Surrey Heath Borough Council Deadline 5 Submission

Written Response to the The Examining Authority's written questions and requests for information (ExQ2)

Esso Petroleum Company Limited Southampton to London Pipeline Project Application for a Development Consent Order

DCO.2.31 Potential Additional or Reworded Requirements

## **Appendix B – Construction and Reinstatement Plans**

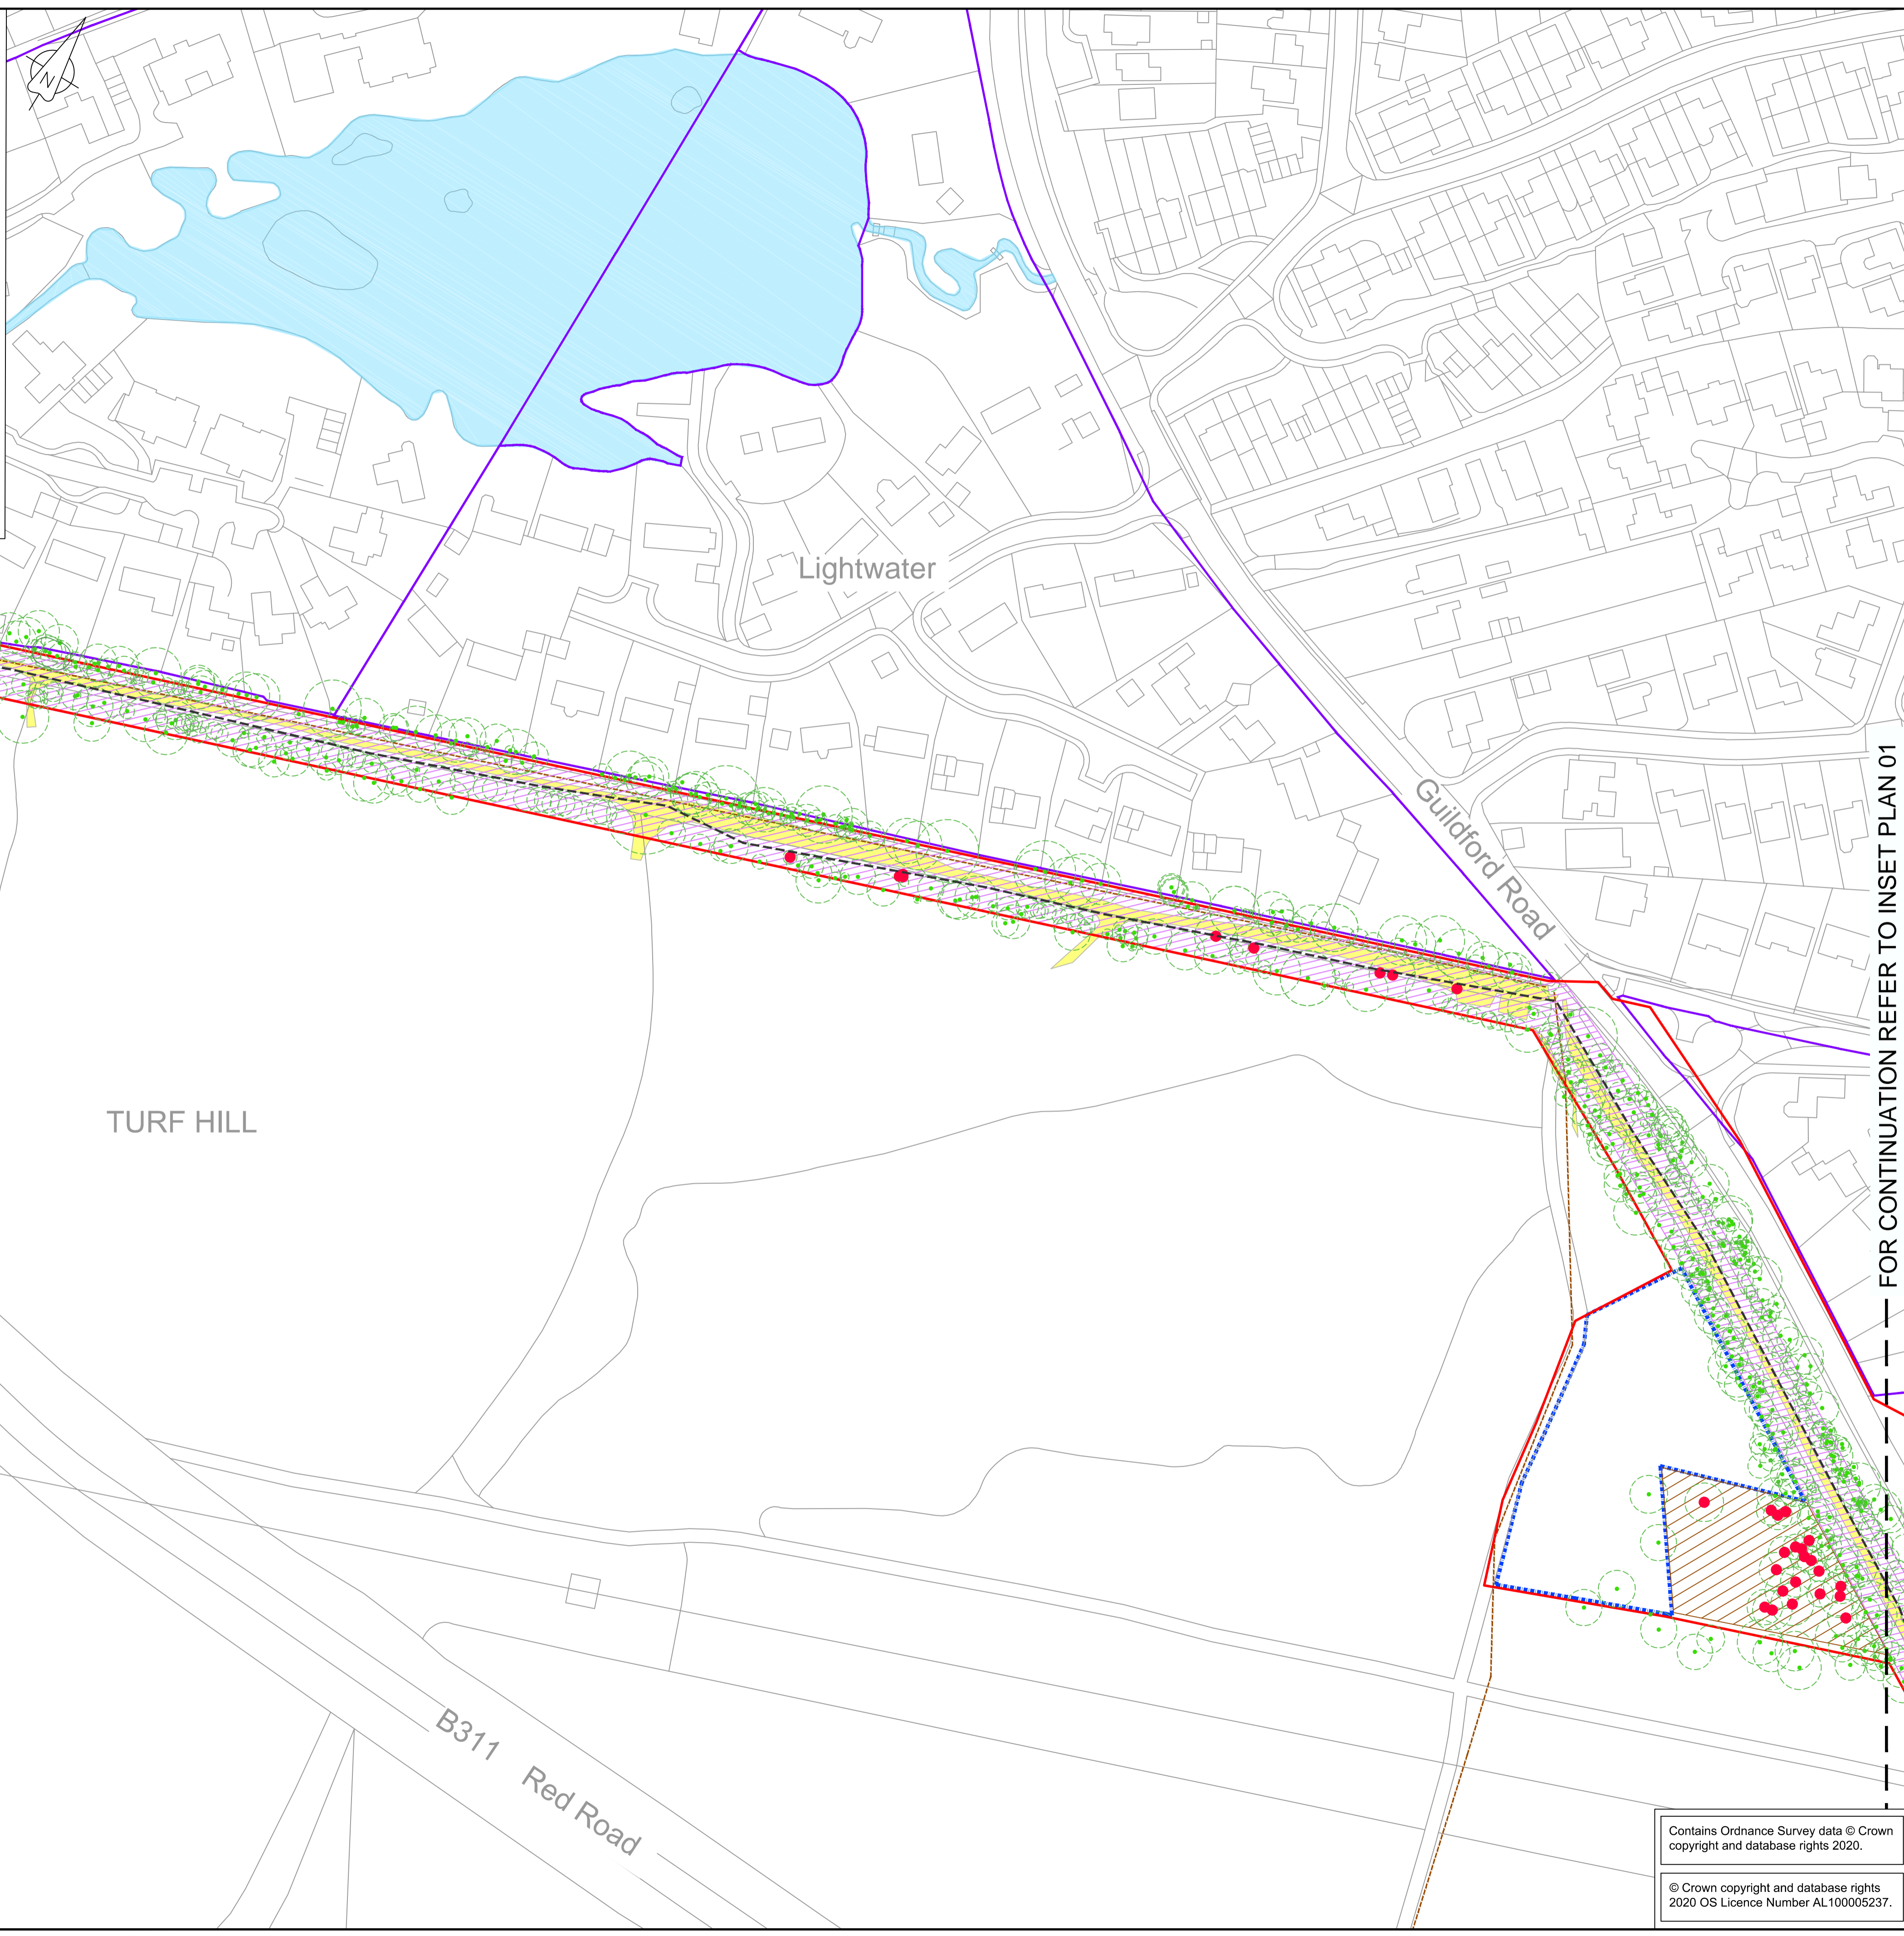
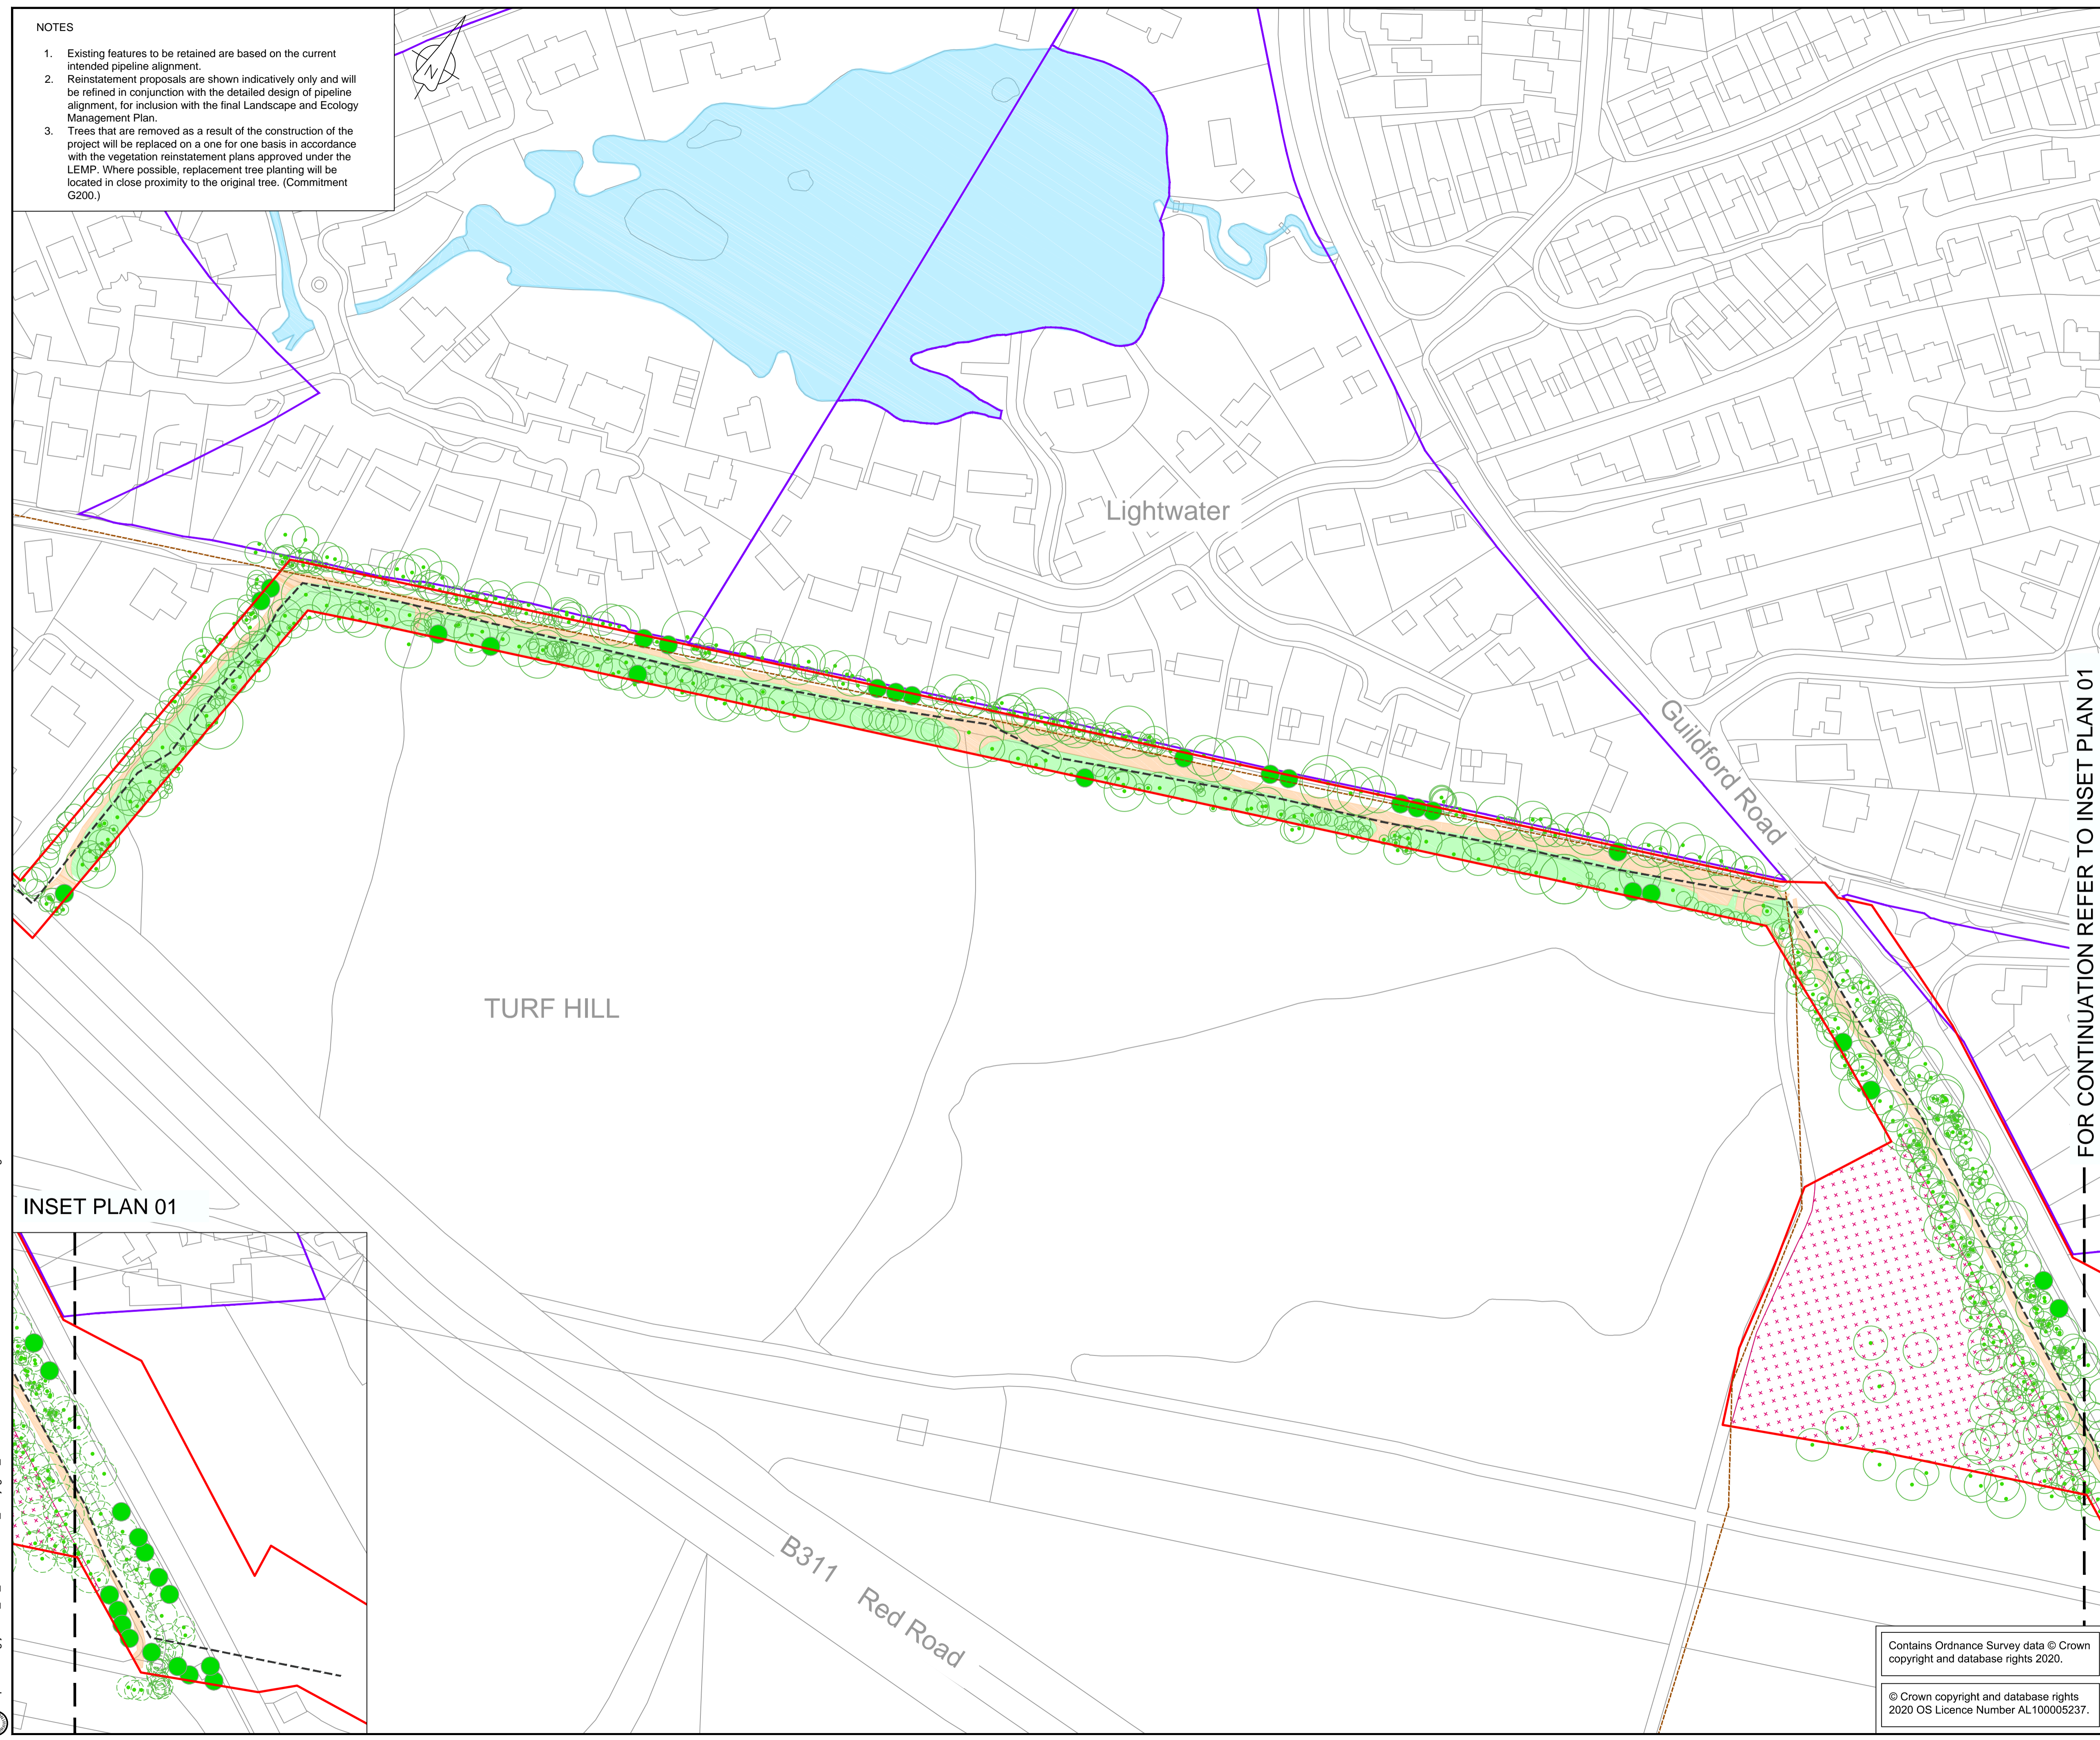
With regard to Appendix B in the Turf Hill Re-instatement plan it shows that both the compound and mitigation area would be re-instated through natural regeneration. It is unclear why the mitigation area would need to be re-instated as it is being shown for mitigation purposes. The same area is shown as habitat creation area on the construction plan so it is unclear to what extent it is intended to be used.

On the drawing entitled Turf Hill: Construction Stage there is a hatched area along the road the notation for which states that "tree removal" is to be confirmed. This area is a main landscape buffer adjoining the Guildford Road. The SSP should survey the relevant trees to BS5837:2012, assess the impact of the trees proposed to be removed and propose mitigation for the trees identified for removal.

It is noted that the reference is made to retaining the trees on the northern edge of Turf Hill which adjoin the residential properties to the North and appendix B does identify trees to be removed.
